From: Chris Costelloe (The Victorian Society) [chris@victoriansociety.org.uk]

Subject: Comments on application 3/2012/0074 - Victoria Hotel, Clitheroe

DWG. DESCRIPTION		
Existing & Proposed Elevations		
JOB TITLE		
The Victoria Hotel, Market Place, Clitheroe, BB7 2BZ		
CLIENT		
Enterprise Inns Plc		
DWG. BY	SCALE 1:100 @ A3	
DATE	DWG. No	REV
Jan 2012	835.03

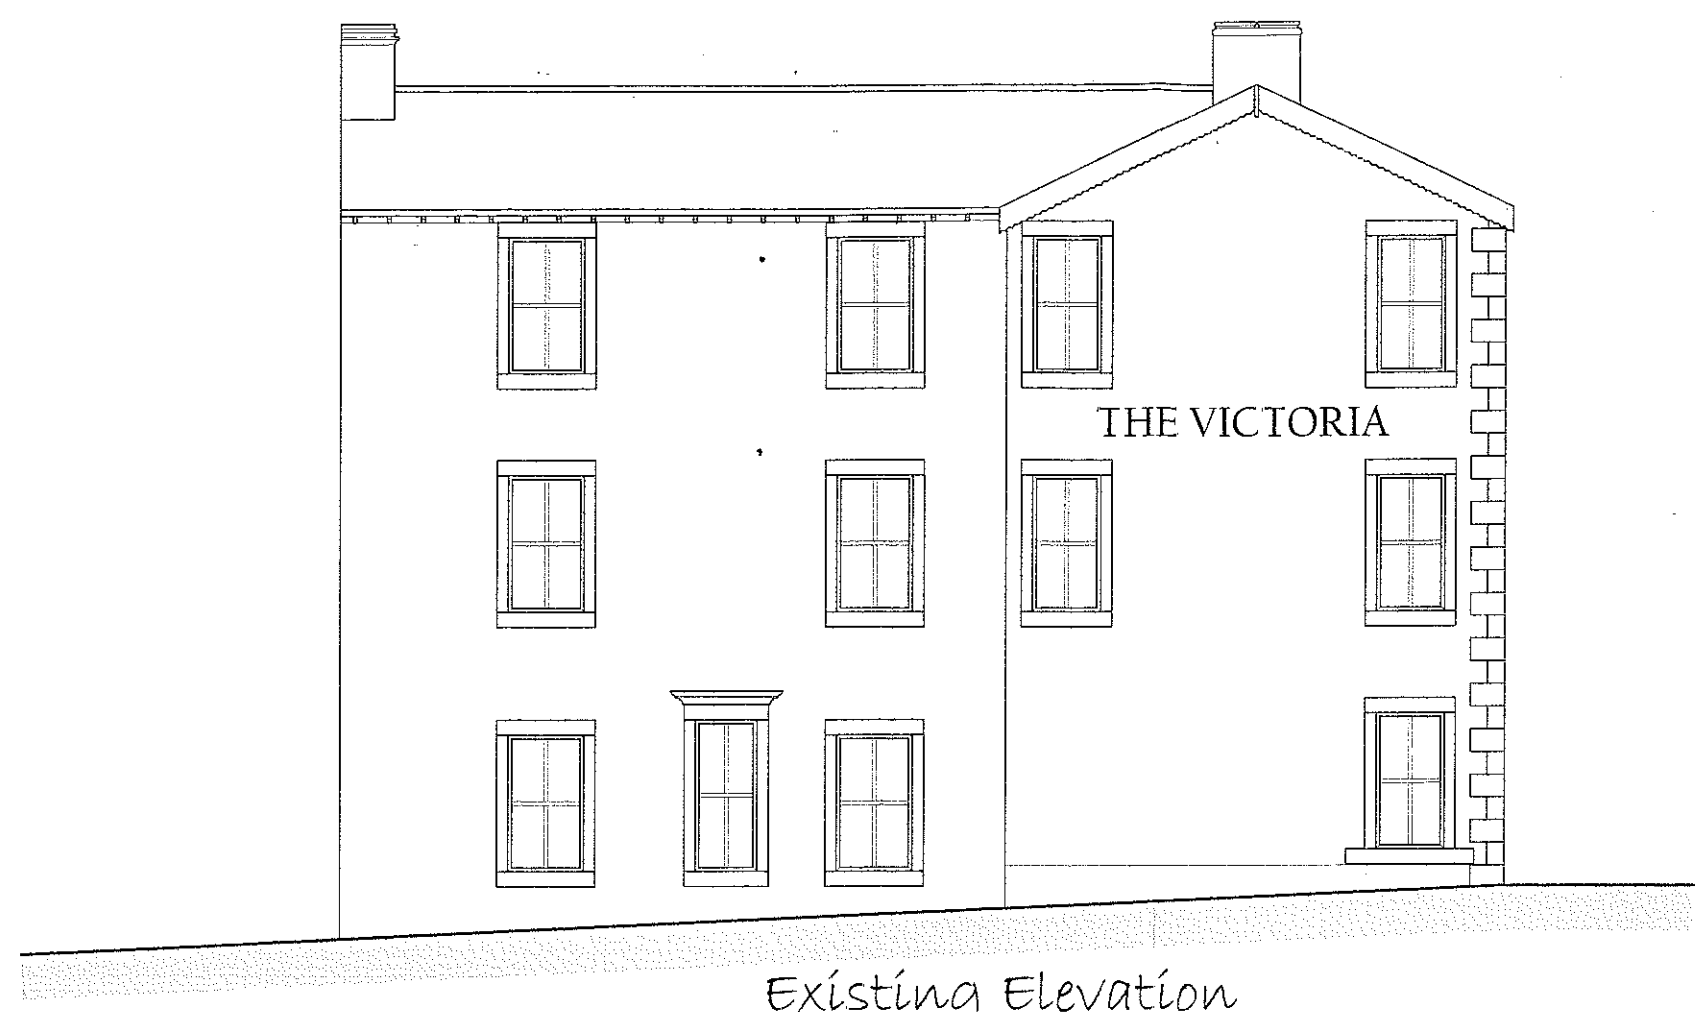
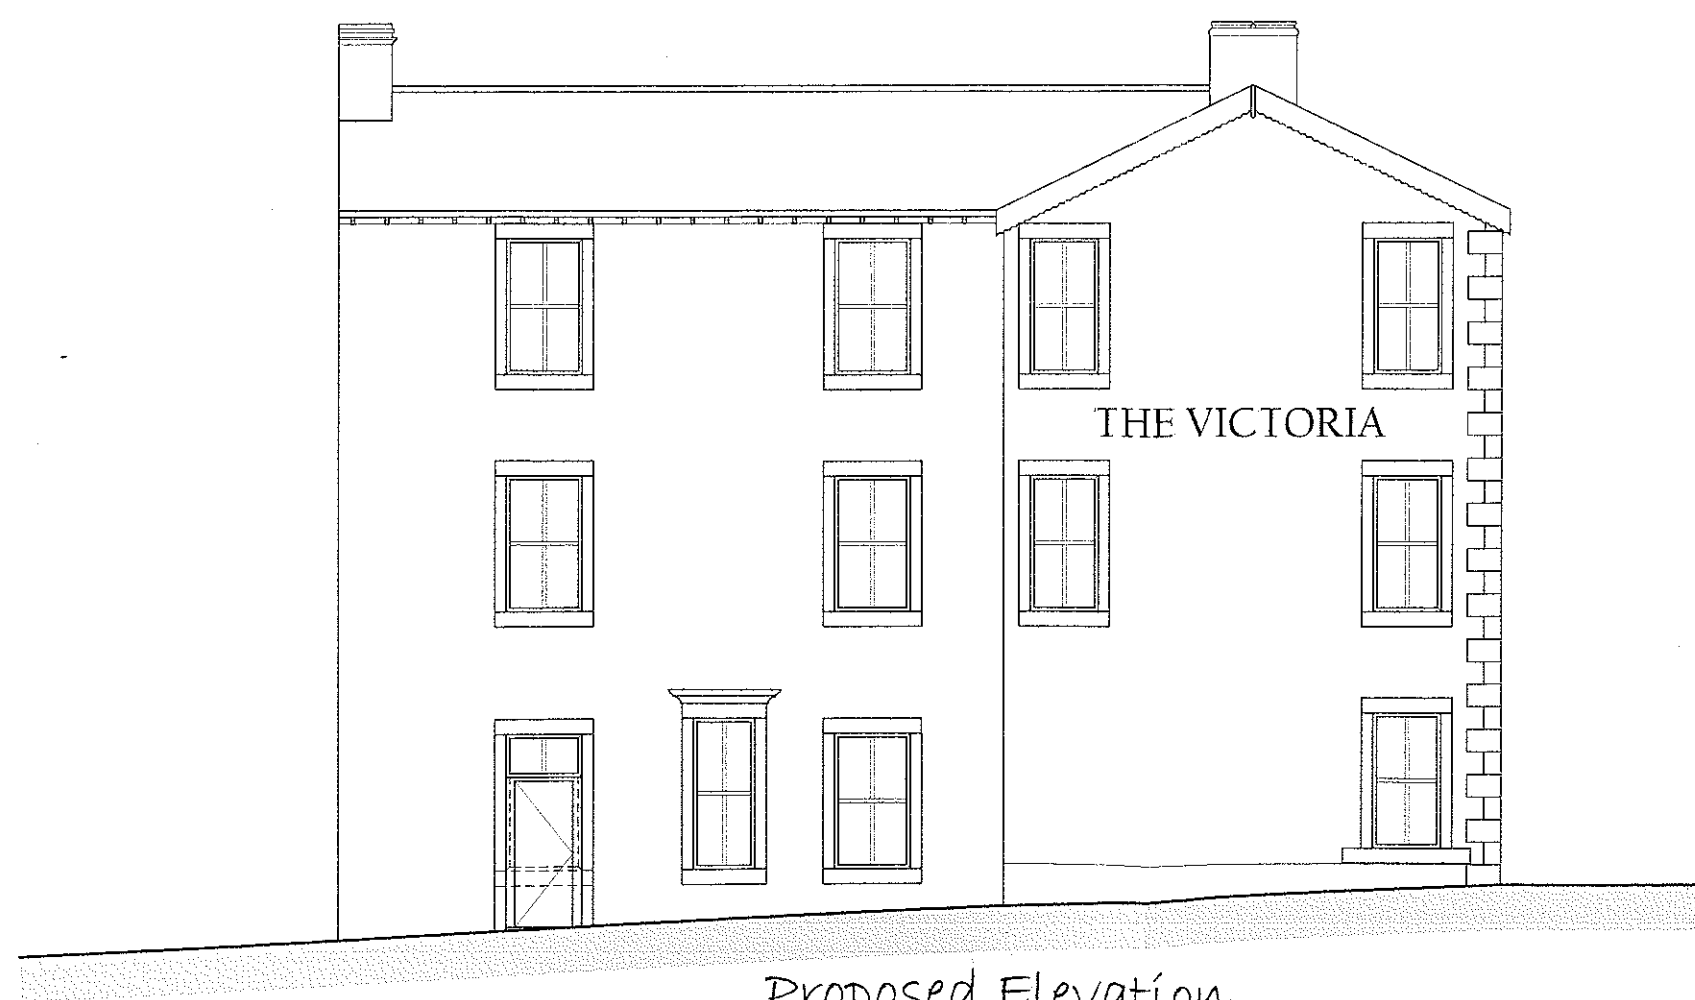
If consent is granted for the change of use, the entrance door to the proposed flats on King Street should be moved to the central of the three openings. There was clearly a central door there historically and it would be damaging to the architecture to insert one in any other position in what was designed as a symmetrical building. We would also like the proposed suspended ceiling in the shop to be omitted; this is not a suitable ceiling treatment for a listed building and would spoil the proportions of the ground floor. Access should continue to be provided to the cellar of the building; this should not be filled in and access will be necessary for maintenance even if the current owners do not wish to use the space.
